INTAKE COMMENTS

Permit # 2305-015

Project Address: 5222 W. Mercer Way

Scope of Work: ADU above garage

ELEVATIONS

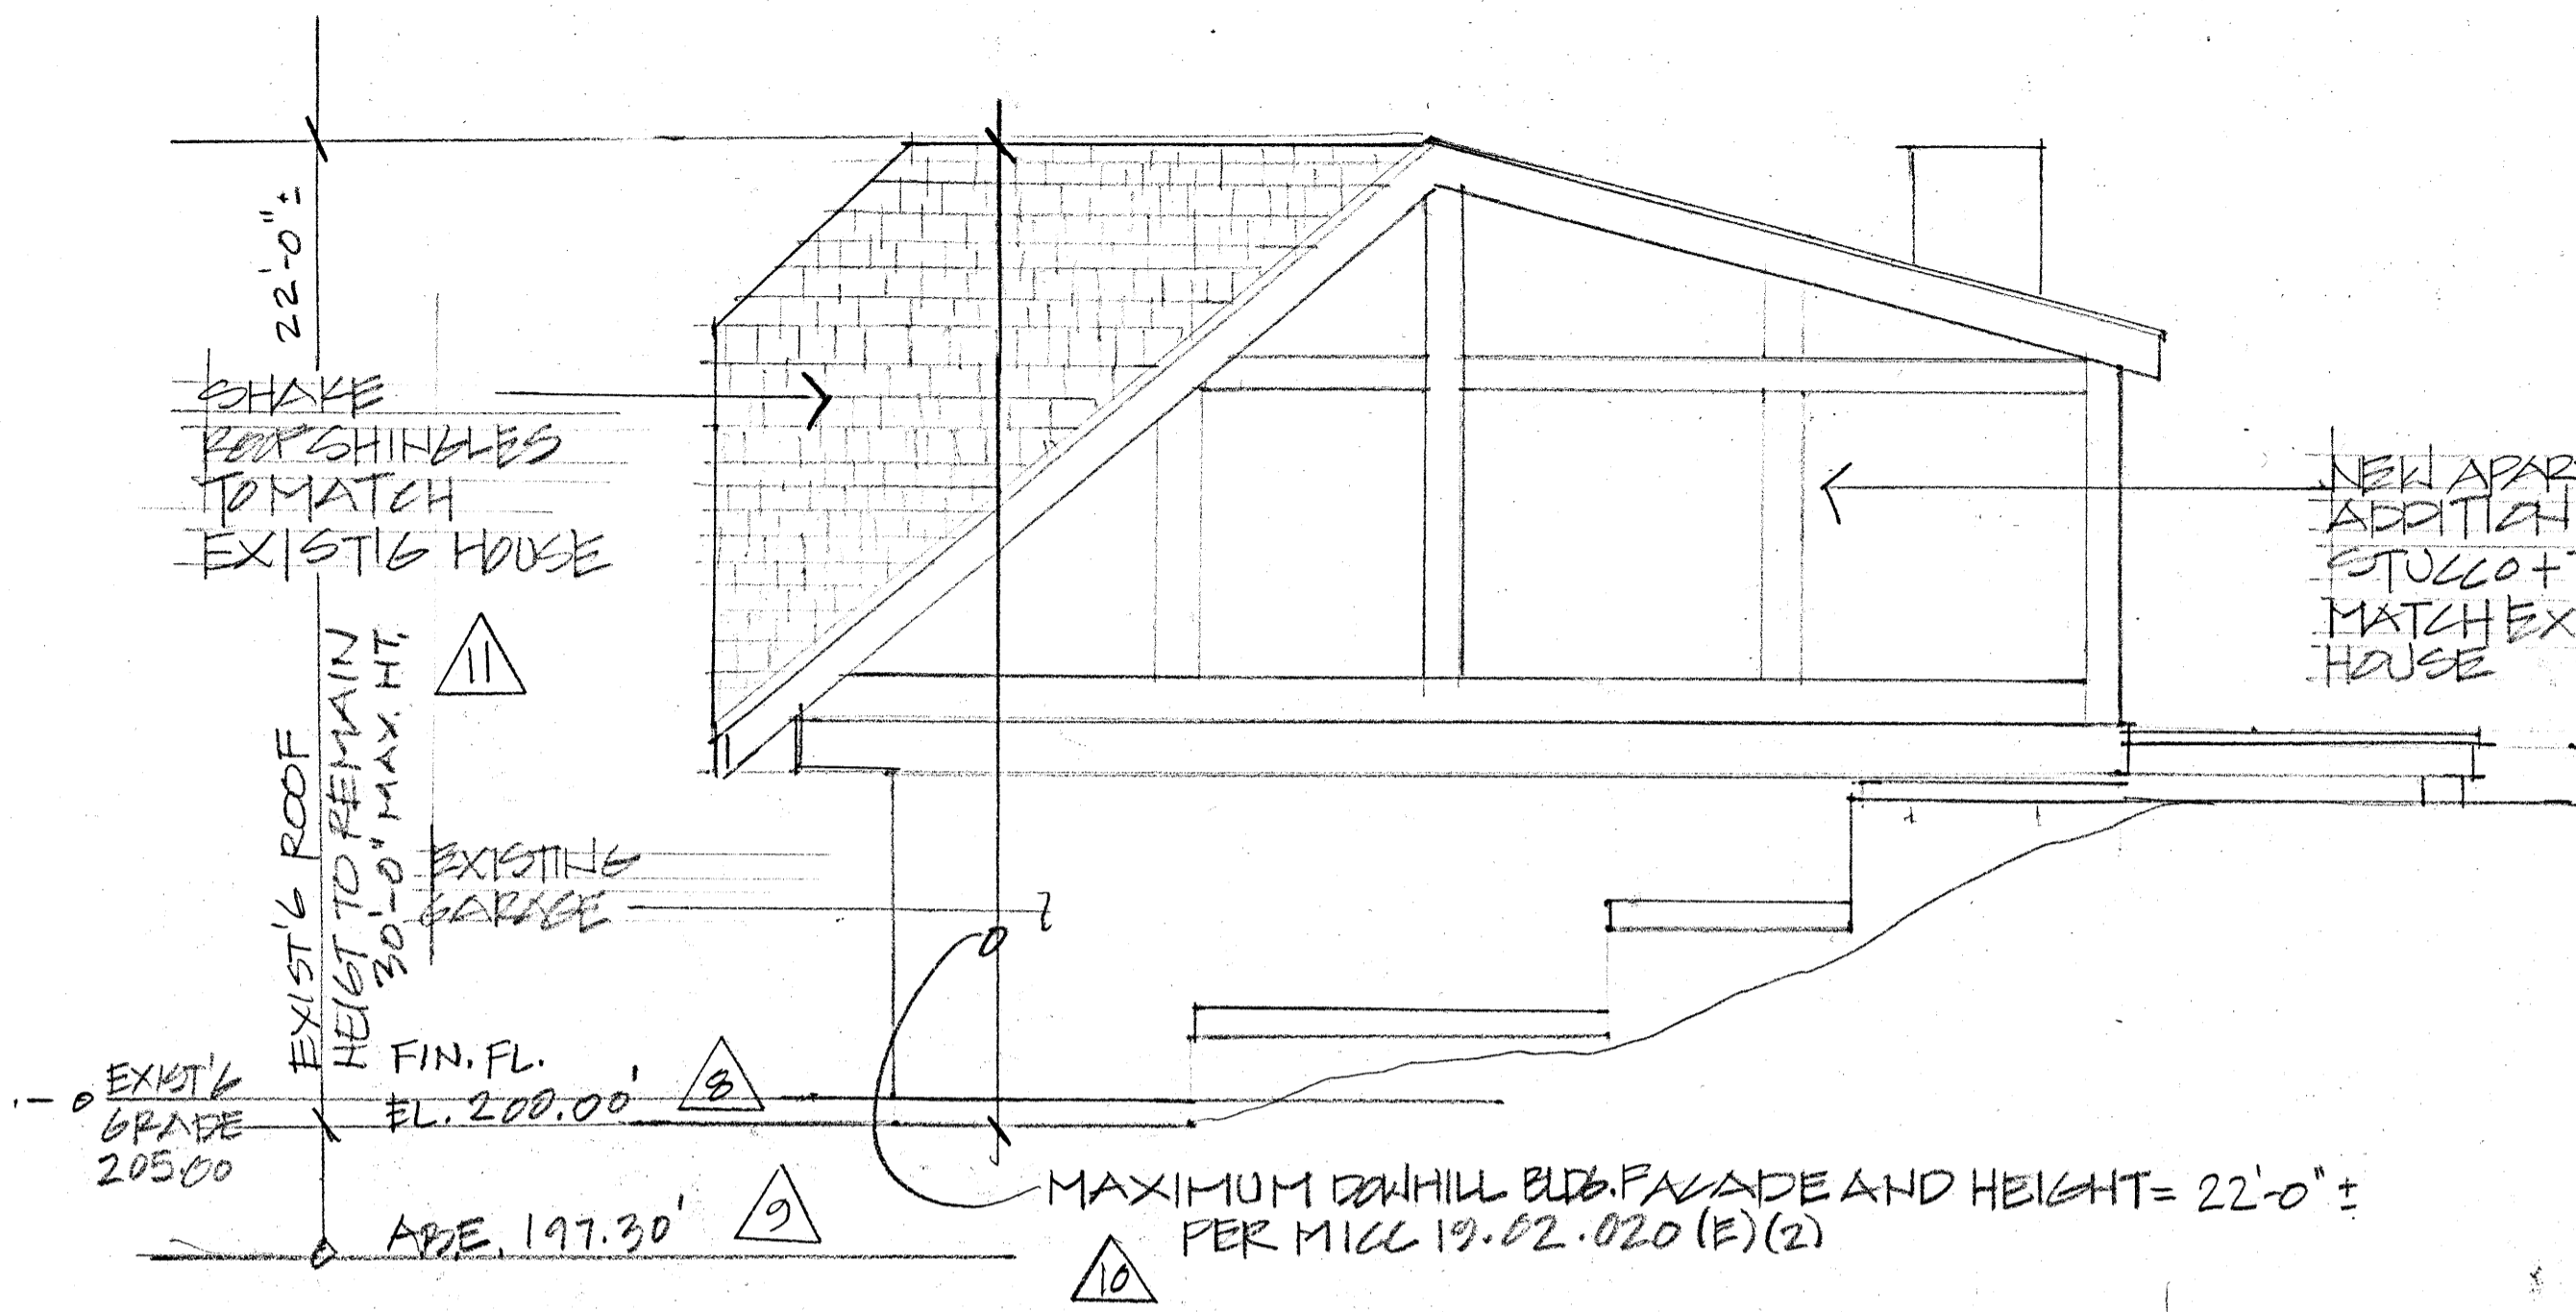
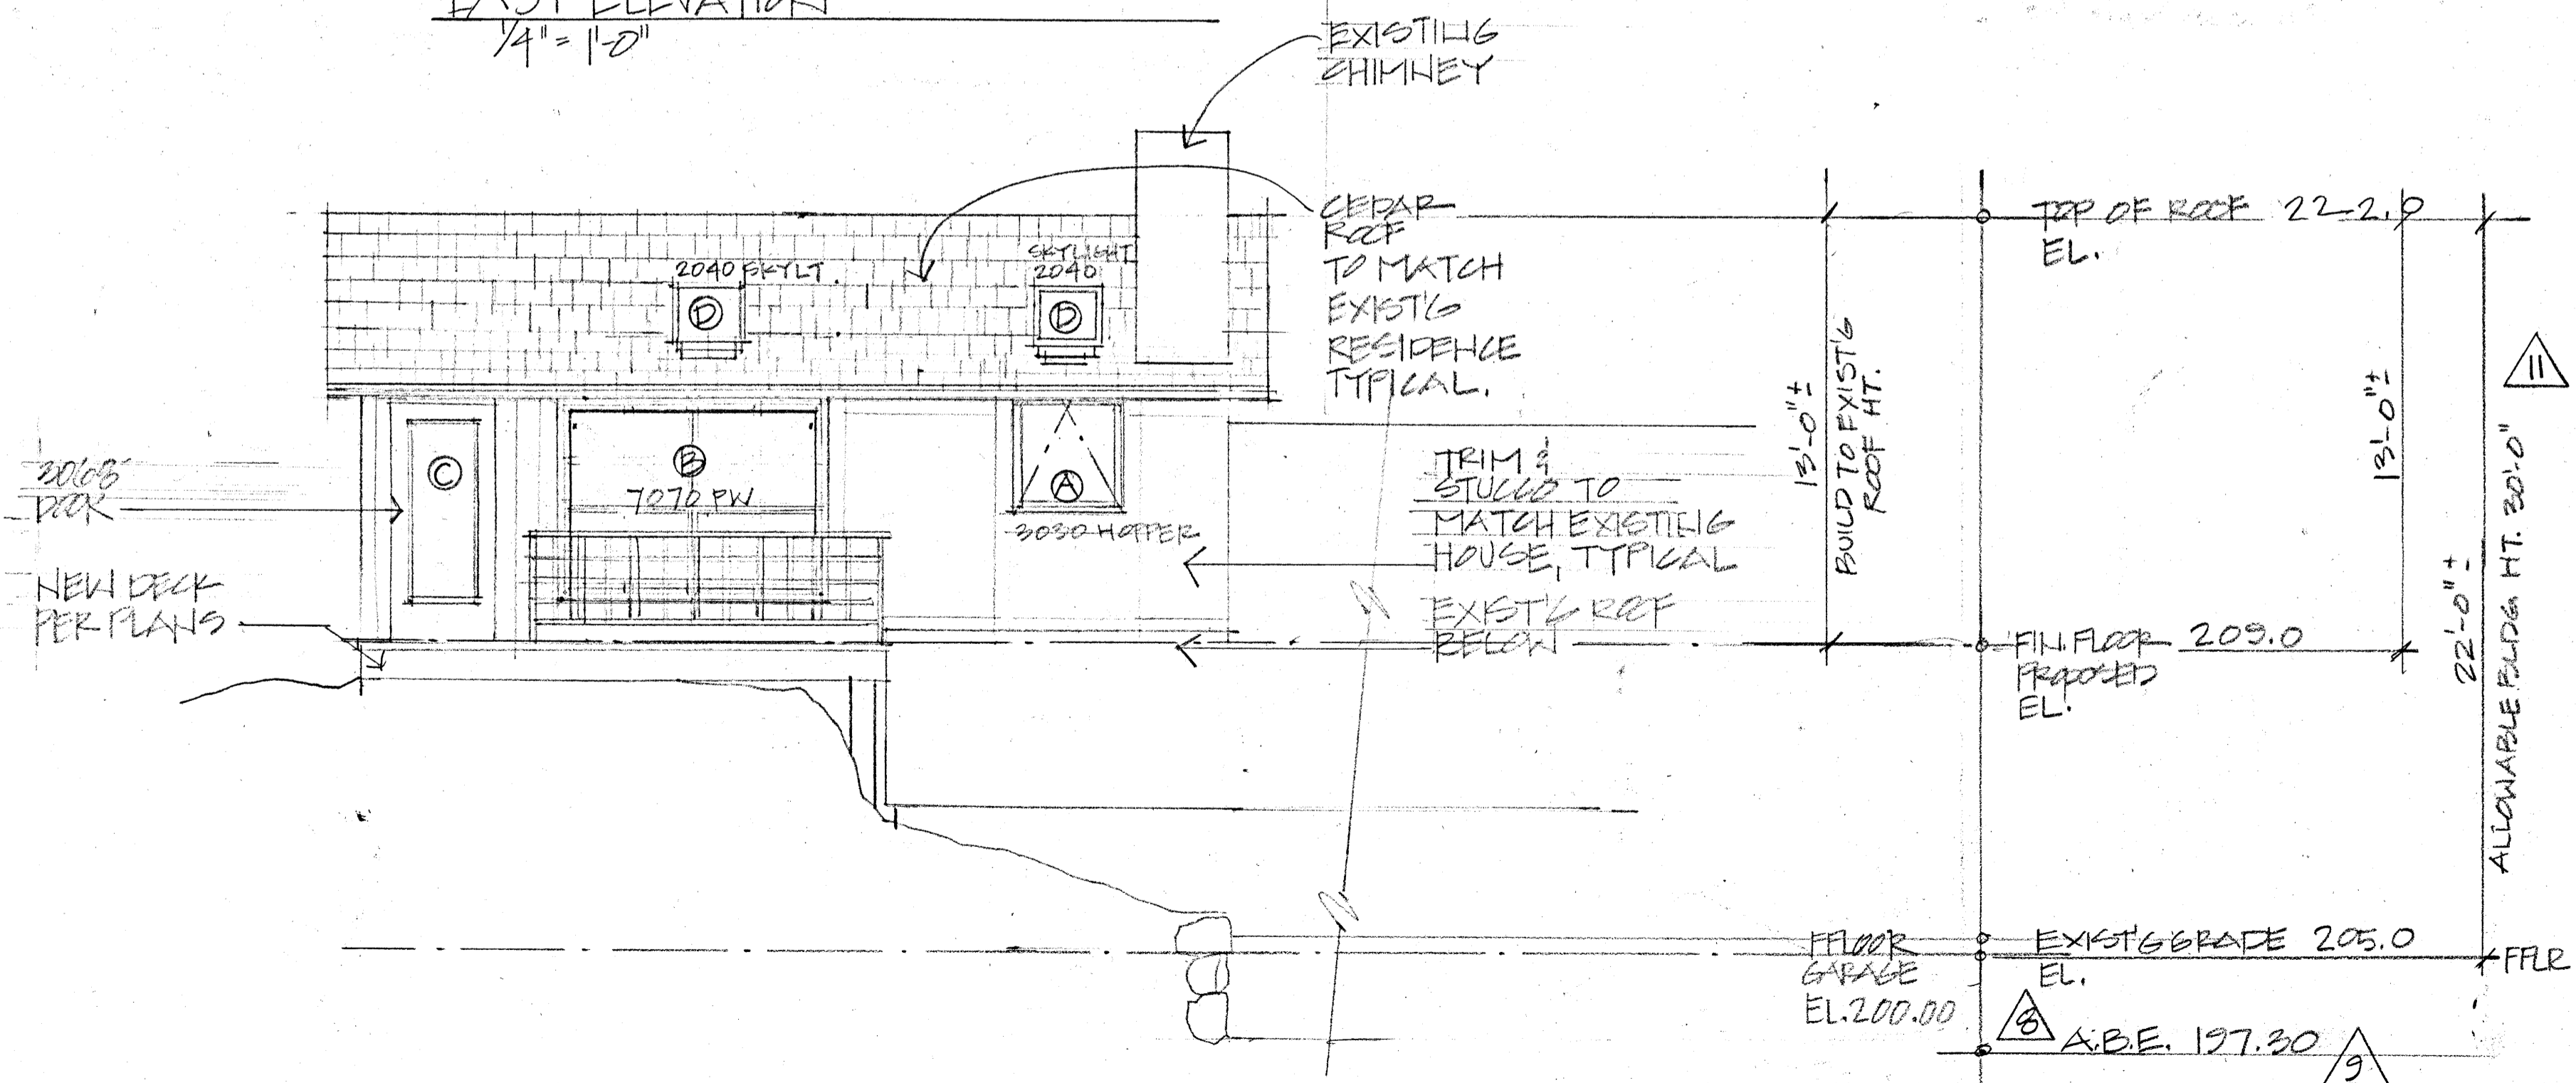
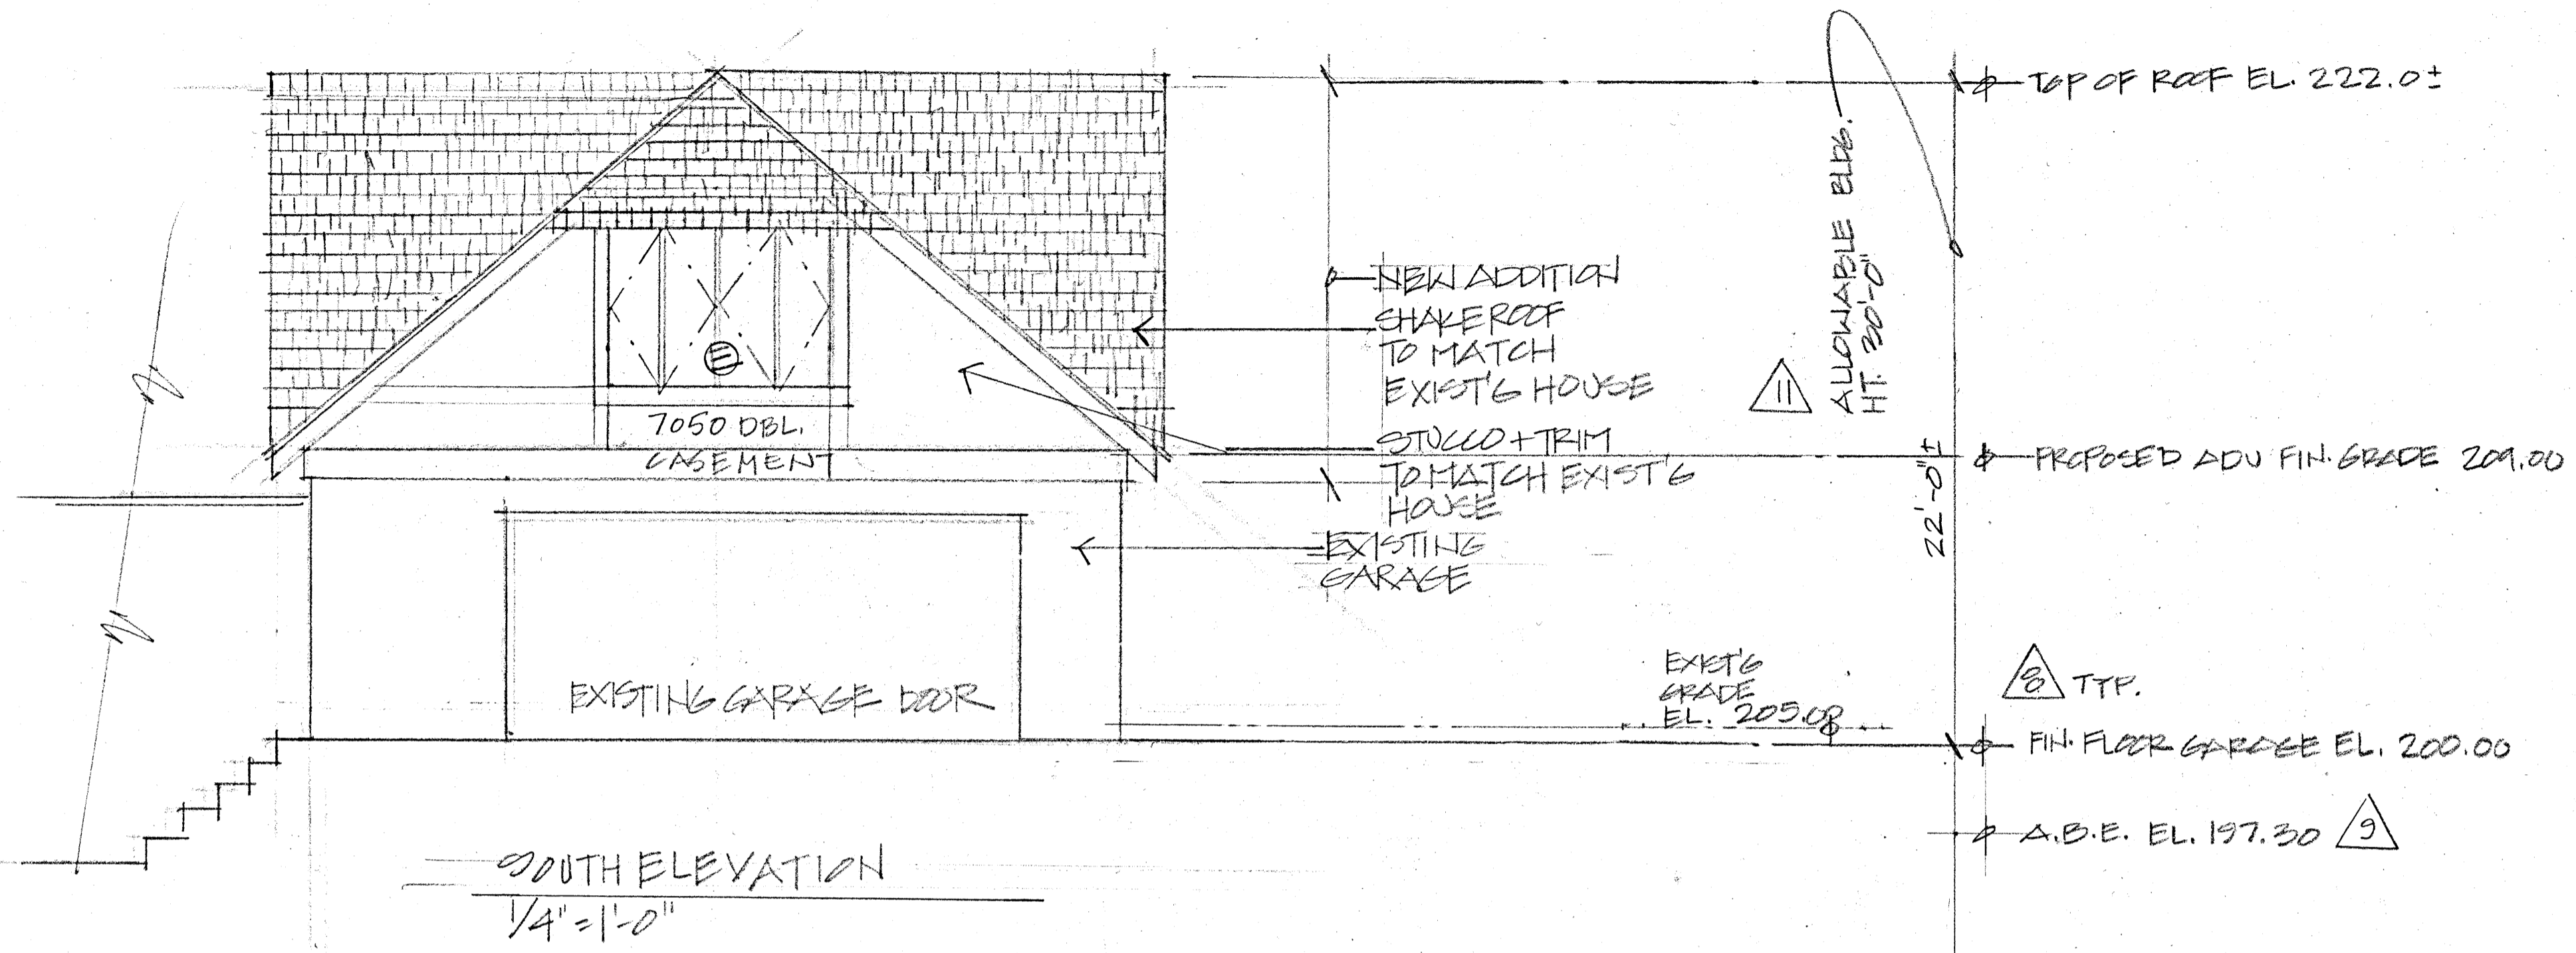
Indicate existing grade and finished grade

Indicate Average Building Elevations (ABE) on all elevation drawings with ABE calcs

Indicate maximum downhill building façade and height

Indicate allowable building height on al elevation drawings

Please show the existing grade, finished grade, average building elevation, maximum allowed building height, and maximum downhill facade height on the elevations. Note 8

Please also provide calculations for the average building elevation as per MICC 19.02.020(E)(4).

Note 8 Elevation Drawings

Note 9 on Elevation Drawings

Note 10 on Elevation Drawings

Note 11 on Elevation Drawings

Note 9
